Environmental Health Division
1675 W. Garden of the Gods Road
Suite 2044
Colorado Springs, CO 80907
(719) 578-3199 *phone*
(719) 578-3188 *fax*
www.elpasocountyhealth.org

Sunrise Meadow Subdivision, VR-21-7

SITE PLAN

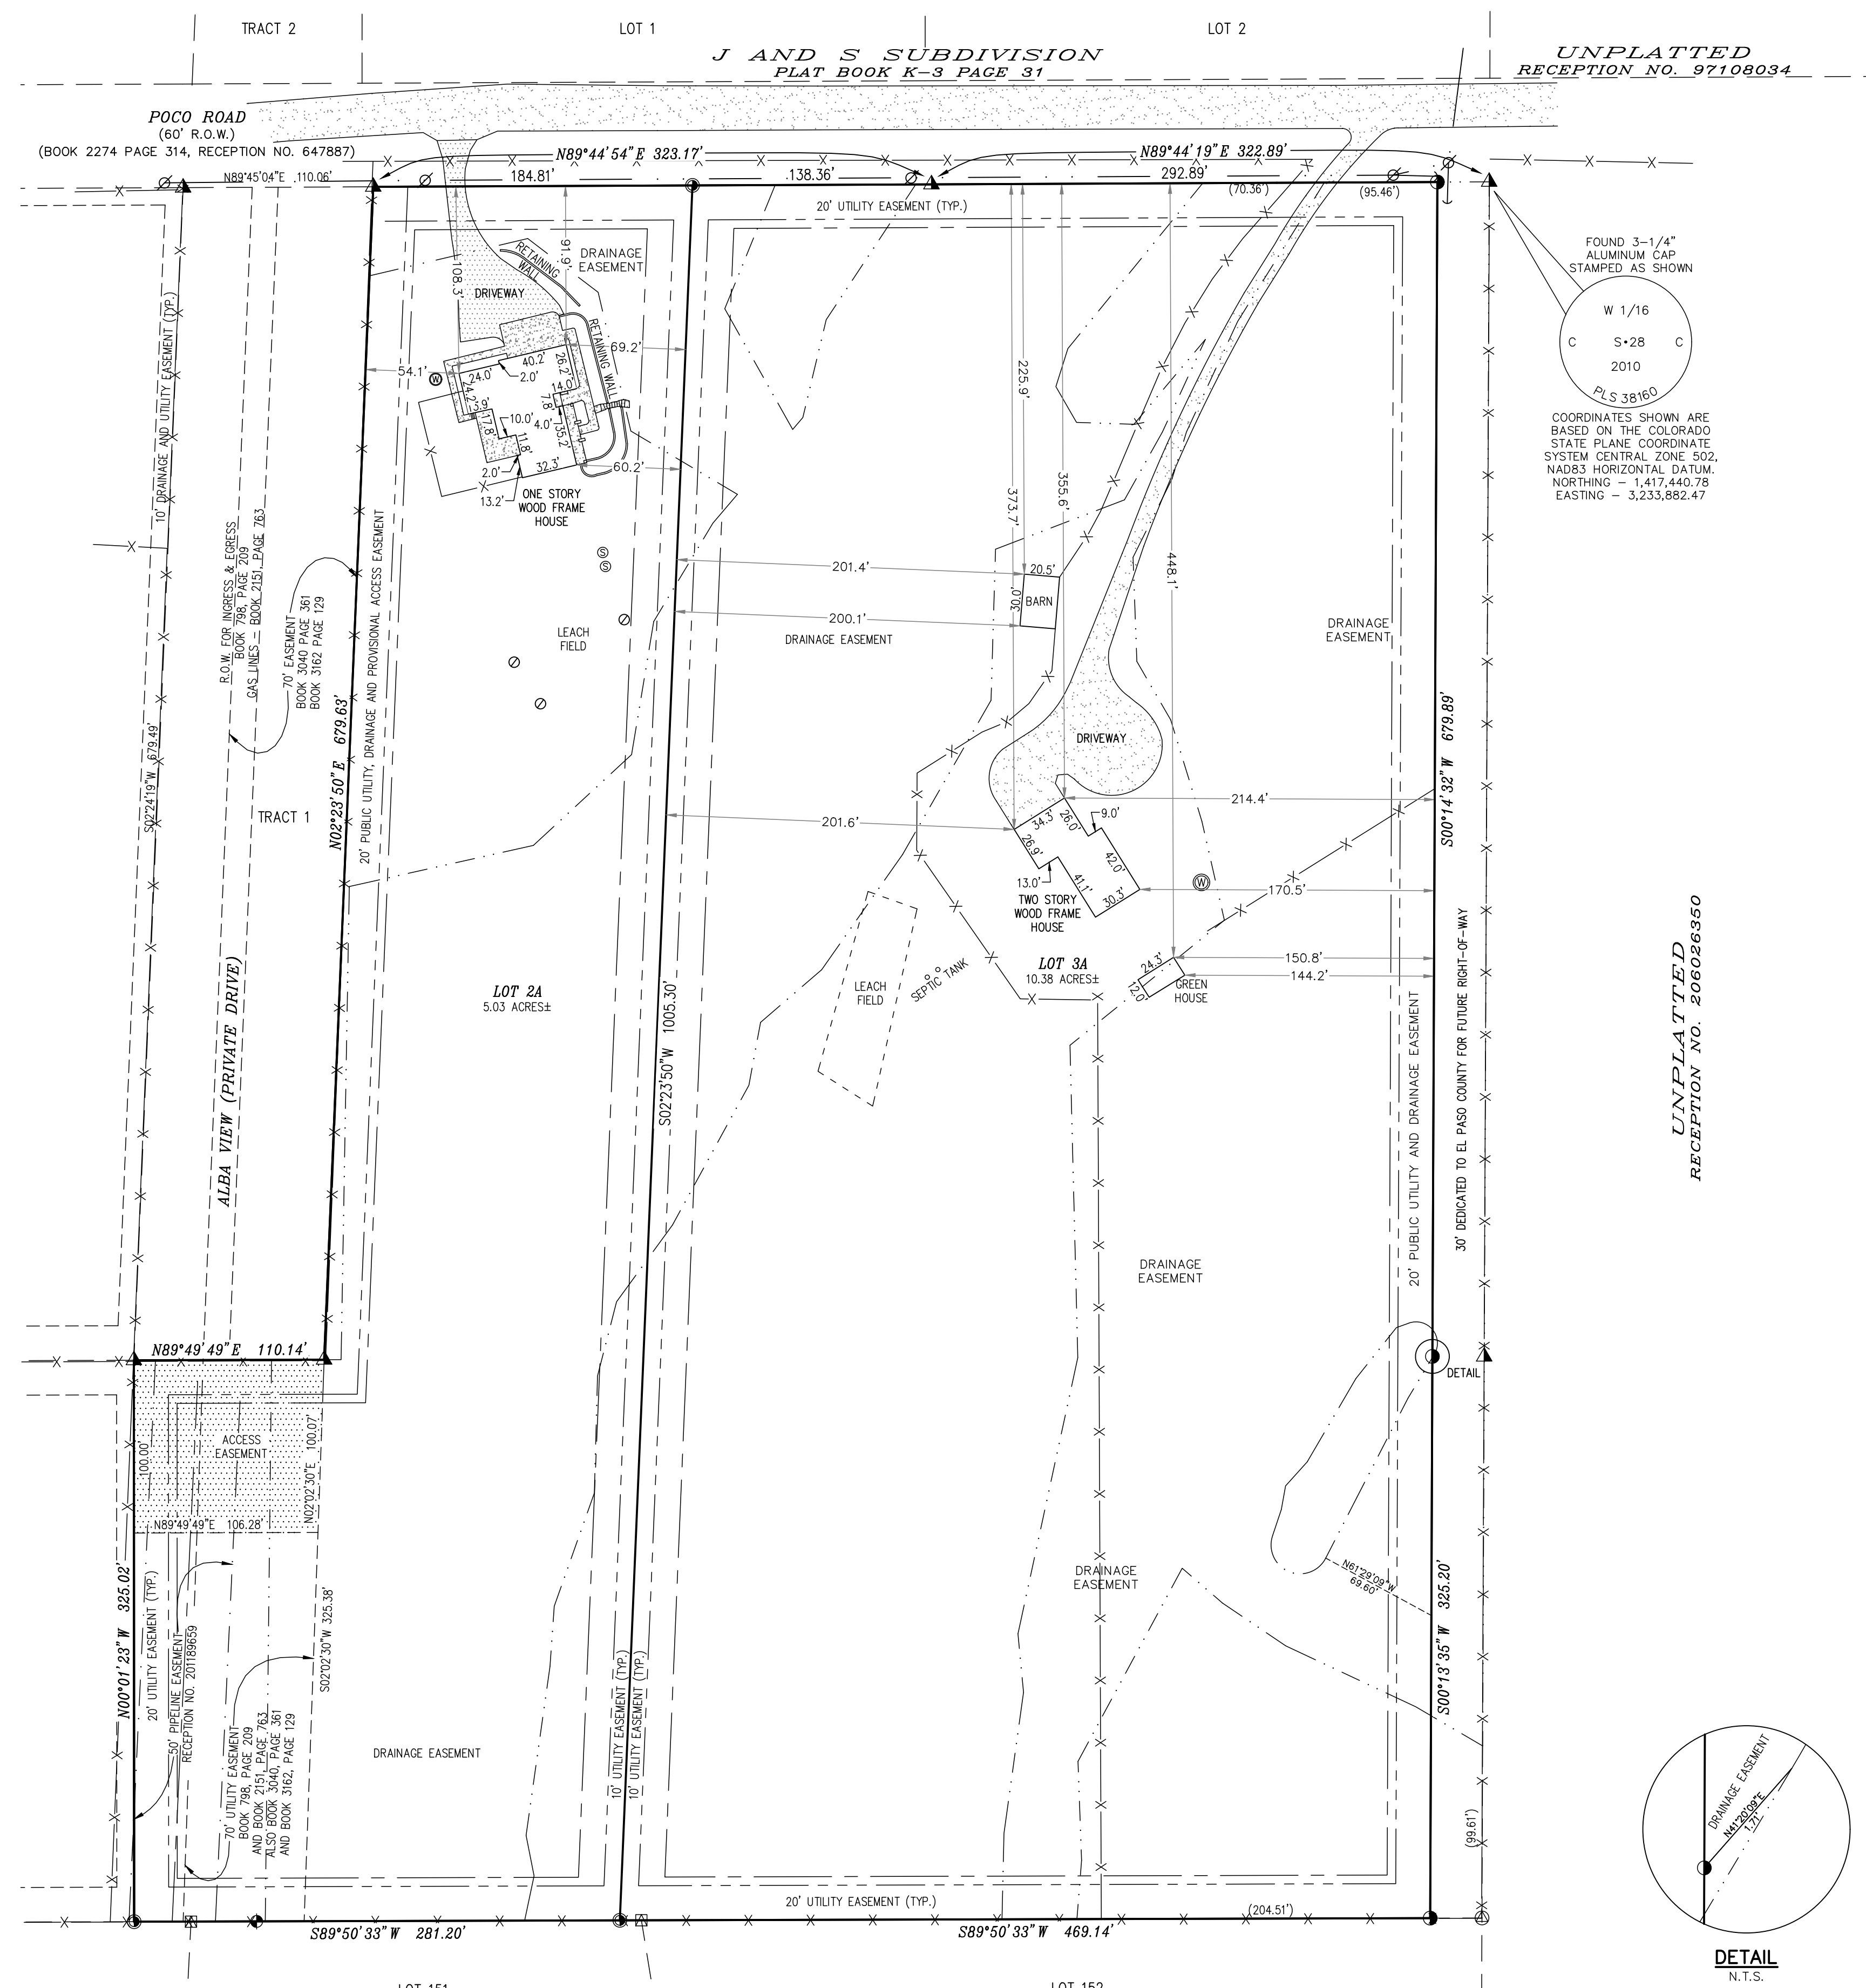
- **There is a decrease in the number of lots (1 lot) from the original approval associated with this request.**
- **The 2 developed lots affected by the lot line adjustments are currently served water by individual private wells and wastewater service by onsite wastewater treatment systems (OWTS). The property addressed as 8125 Poco Road becomes a narrow 5.03-acre lot. The drawing of the approved OWTS installation with component locations on file at El Paso County Public Health is not drawn to scale; however, it appears that all components of the soil treatment area (STA) will maintain the minimum horizontal setback of 10' from the property lines. It is recommended to have this verified by the property owner. Please be aware the alternate or secondary STA site must also meet the minimum setback of 10' should it ever be necessary in the future.**
